Great Yarmouth Third River Crossing Application for Development Consent Order

Document 6.7: EIA Scoping Opinion

SCOPING OPINION:

Proposed Great Yarmouth Third River Crossing

© Crown copyright and database rights 2017. Ordnance Survey 100019340

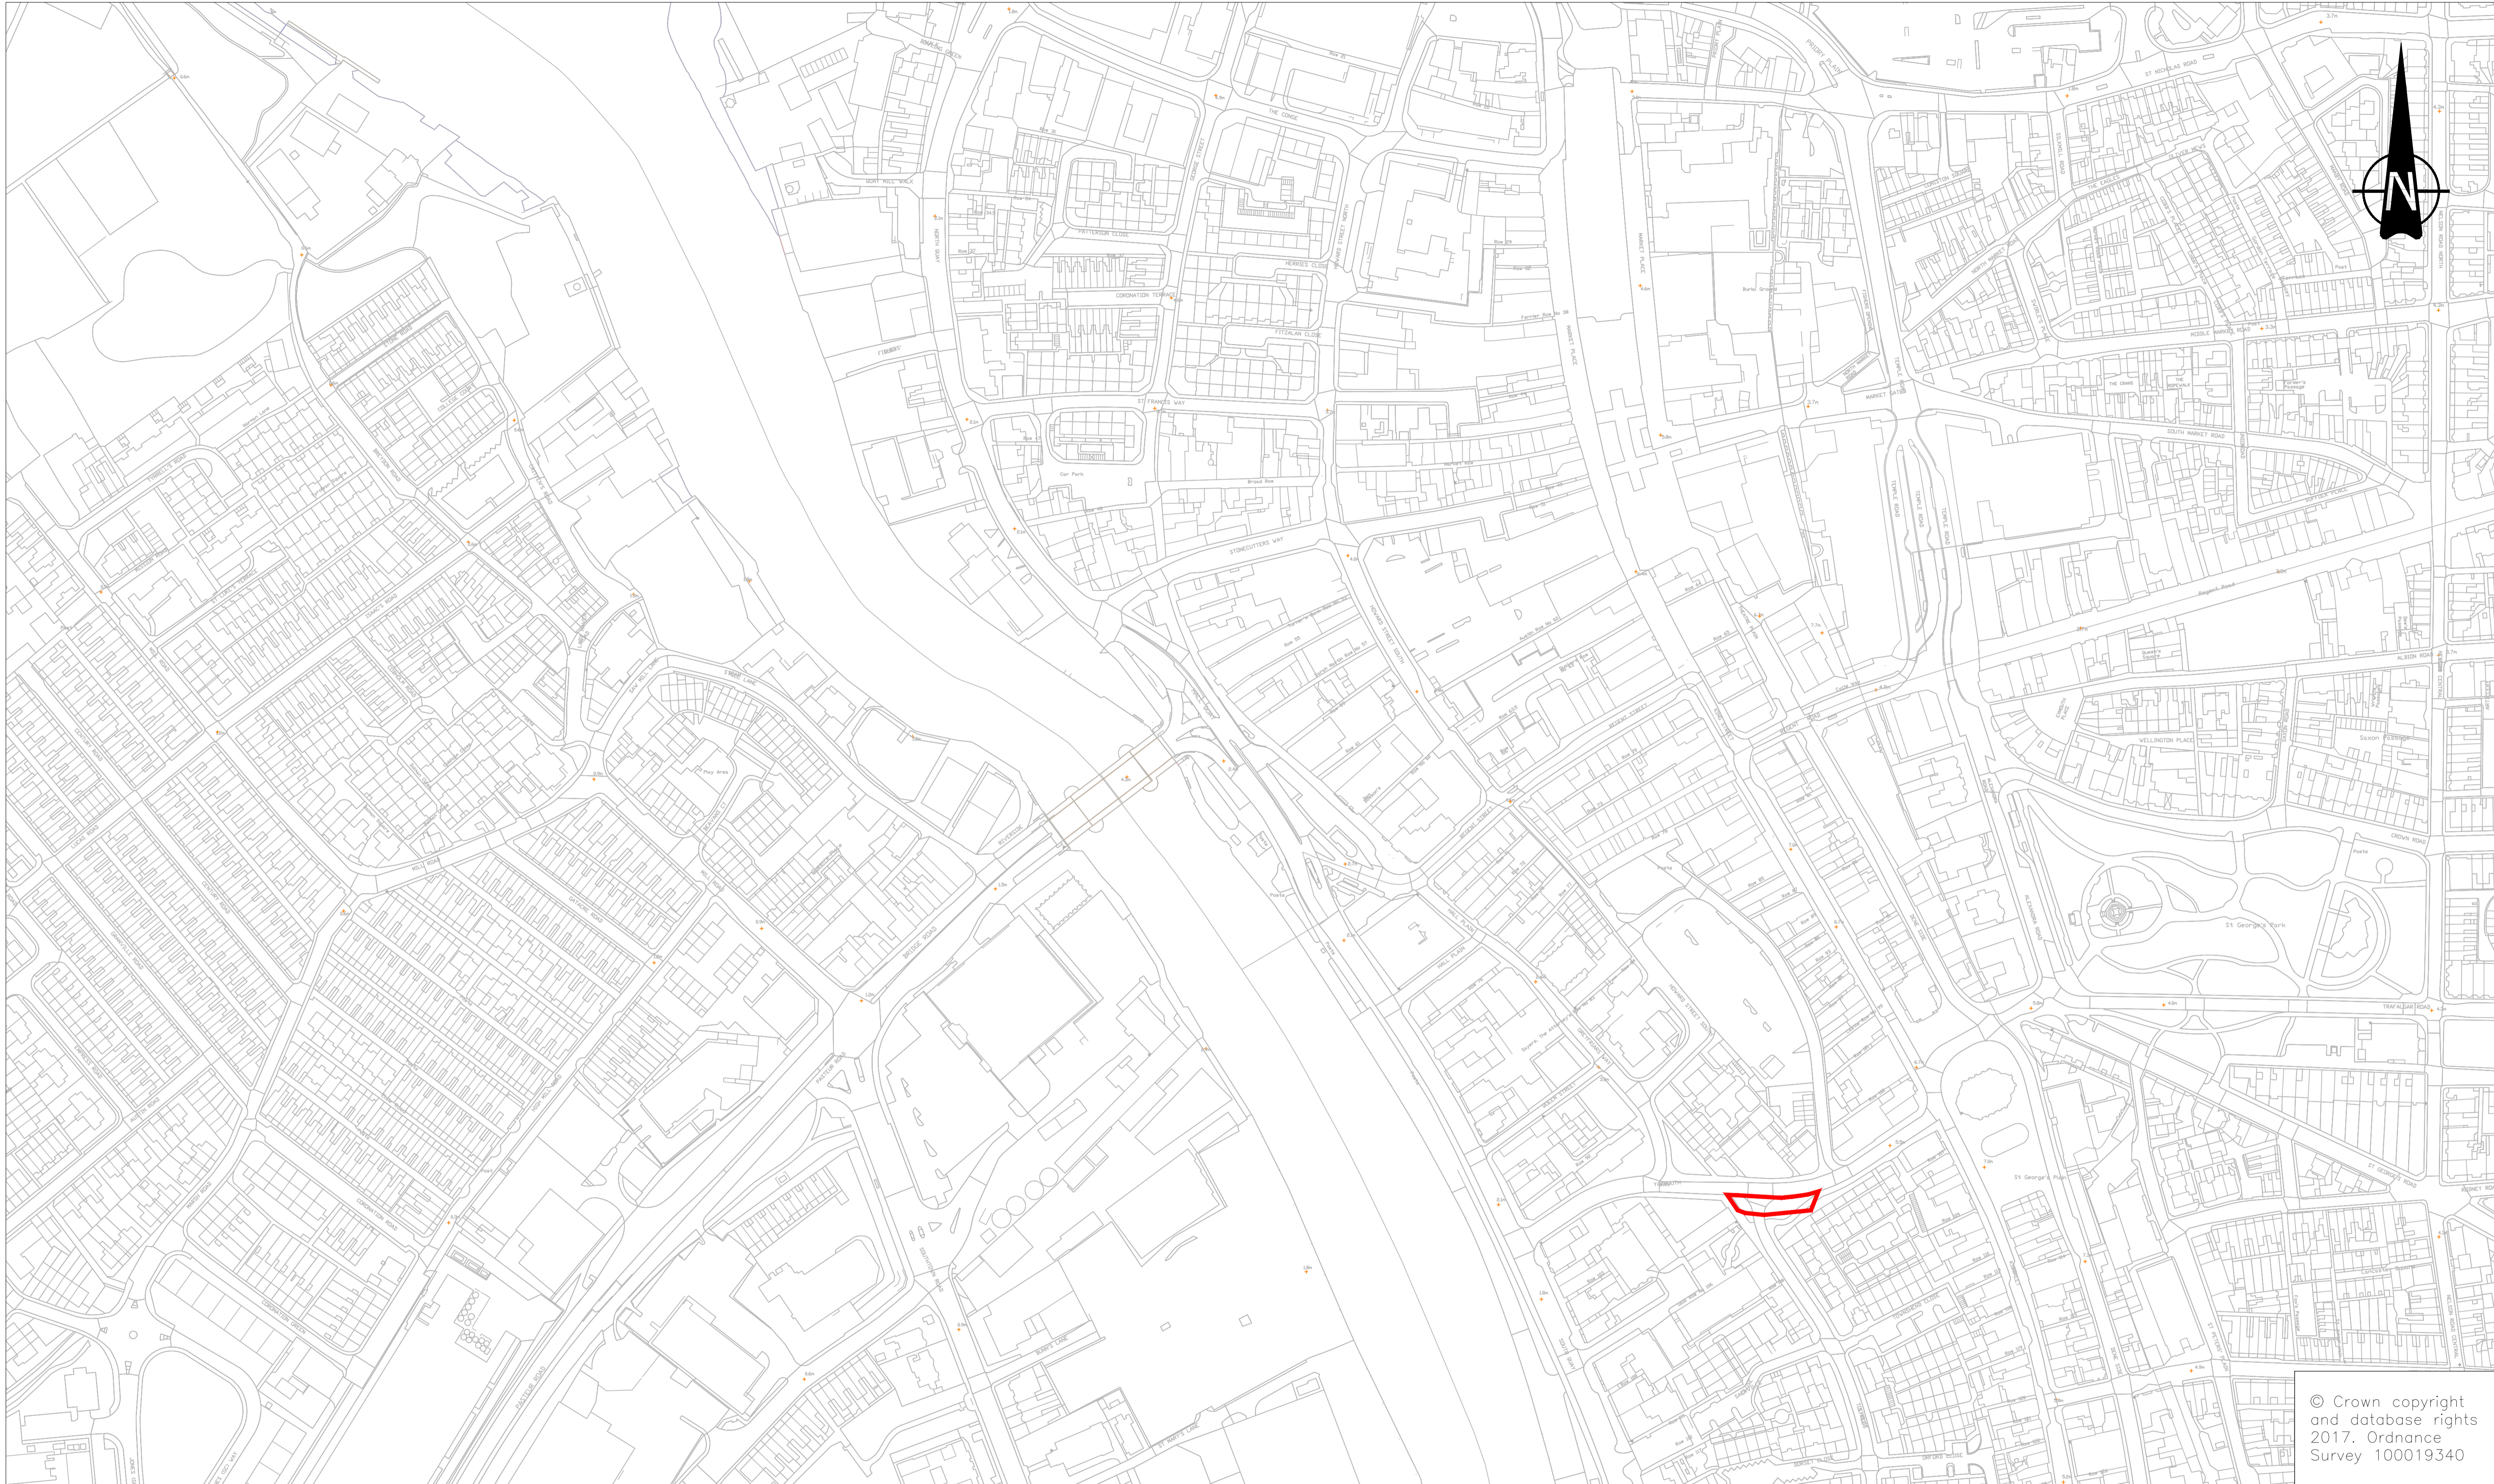
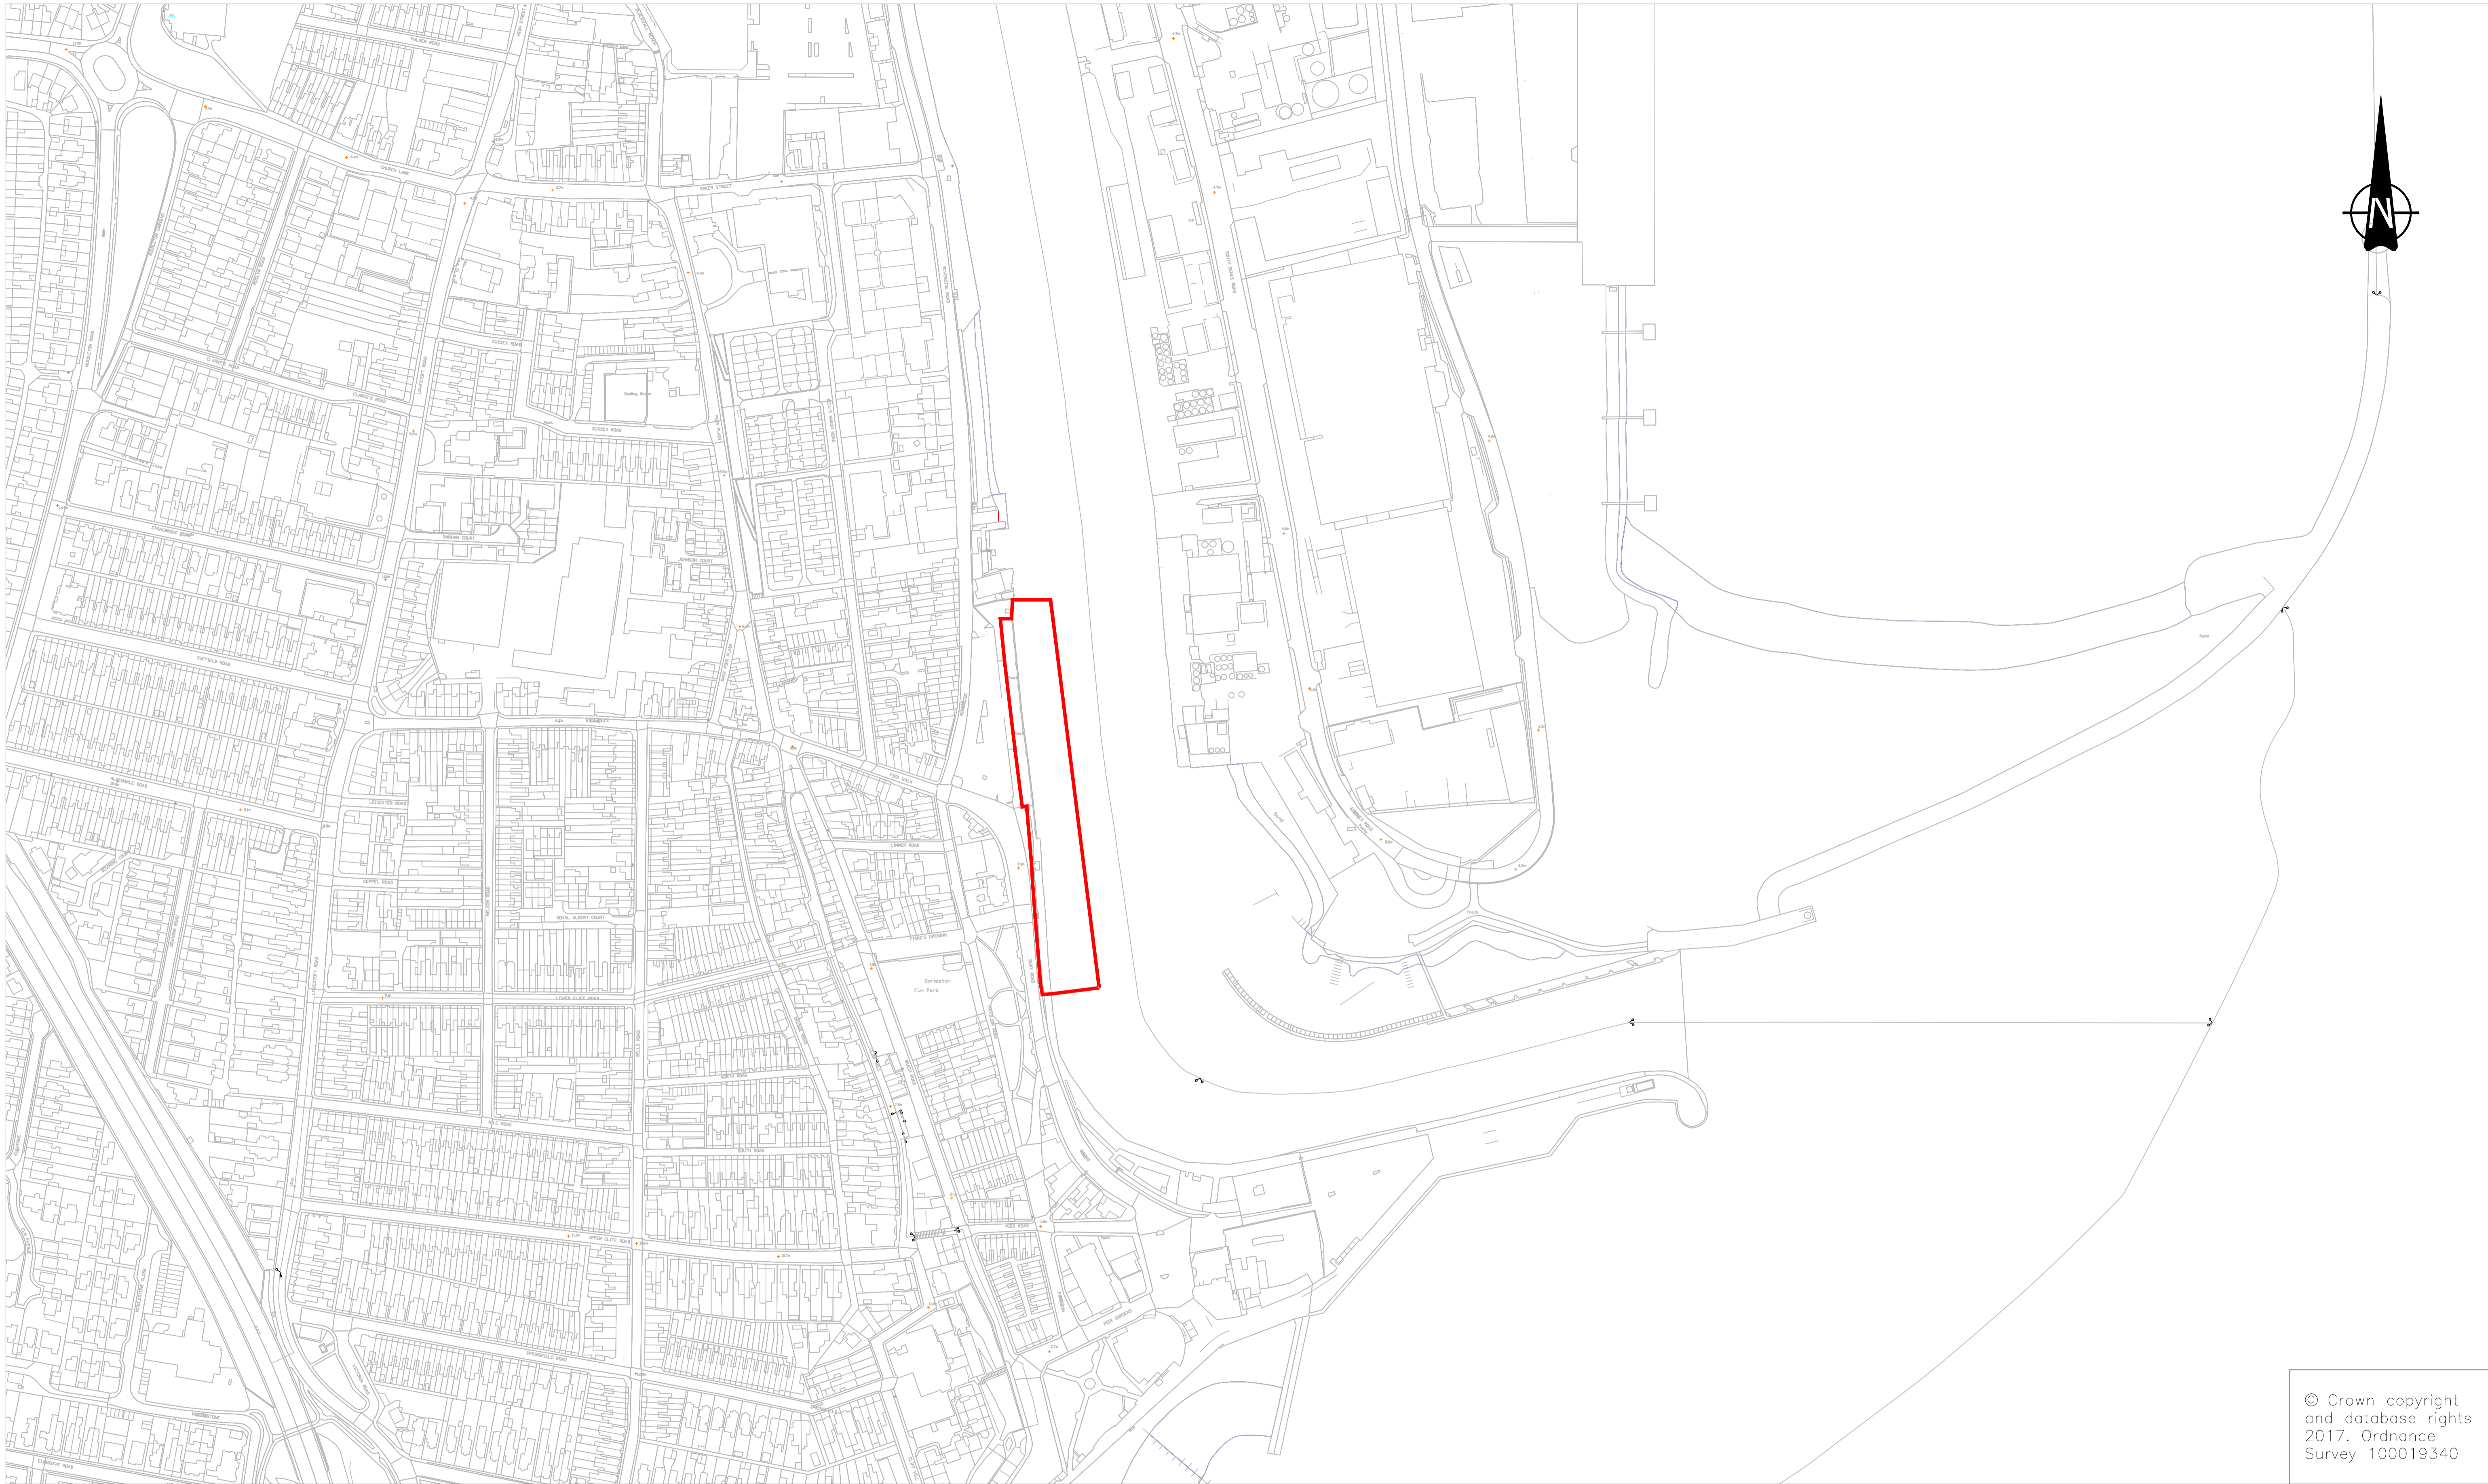
- 2.3.1 A description of the Proposed Development has been provided in Section 2 of the Scoping Report, supported by drawings and figures. The Inspectorate notes that the site boundary shown on Figures 2 to 5 in Appendix B is slightly different to the Scoping Report Boundary presented on drawing 62240375-GYTRC-Scoping Report Boundary-20180219. The Applicant should ensure the DCO application boundary for the Proposed Development is consistent on all drawings and figures that present this information in the ES, and ensure that the impact assessments have considered the full extent of the final DCO application.
